# CITY OF ALBUQUERQUE

January 10, 2023

**Re: Lupe's Cafe**  
**1524 Central Ave. SE**  
**30-Day Temporary Certificate of Occupancy**  
**Transportation Development Final Inspection**  
Architect's Stamp dated 09-30-22 (K15-D102)  
Certification dated 12-28-22

SHEET
TCL

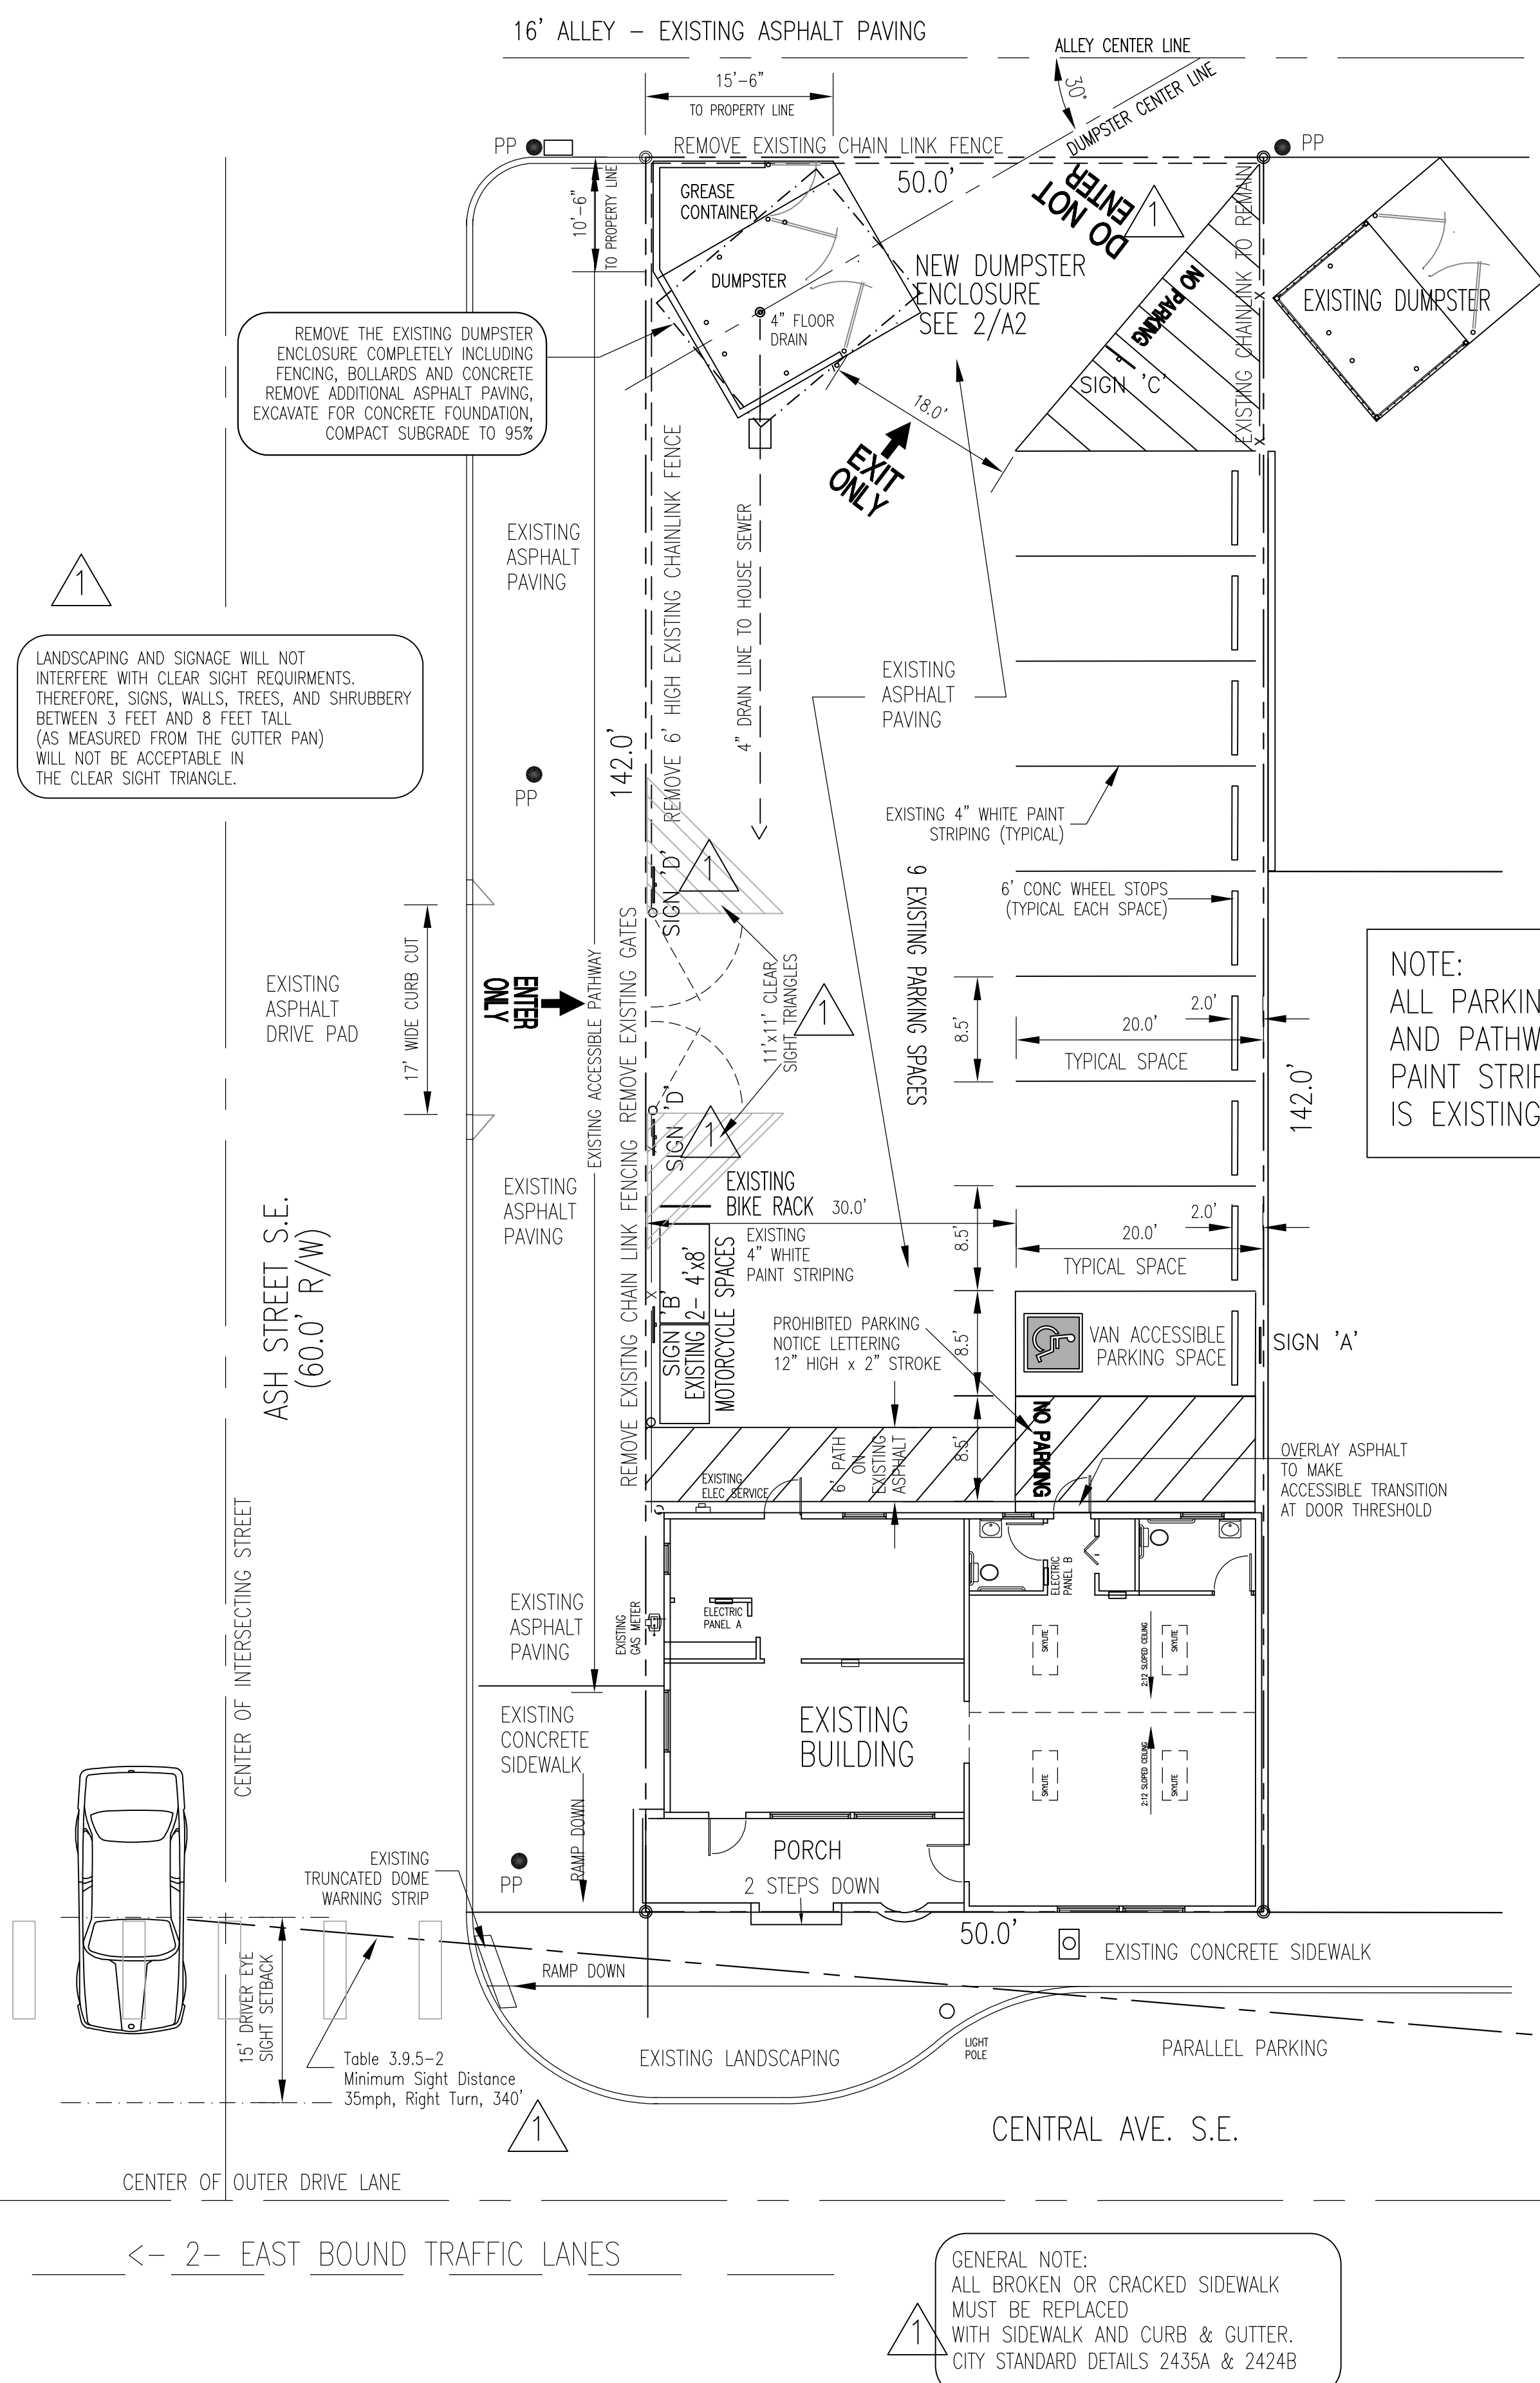
- The ADA accessible parking sign must have the required language per 66-7-352.4C NMSA 1978 **"Violators Are Subject to a Fine and/or Towing."** Please call out detail and location of signs.
- The pavement marking "MC" should be shown in the opposite direction for motorcycles entering the parking space.
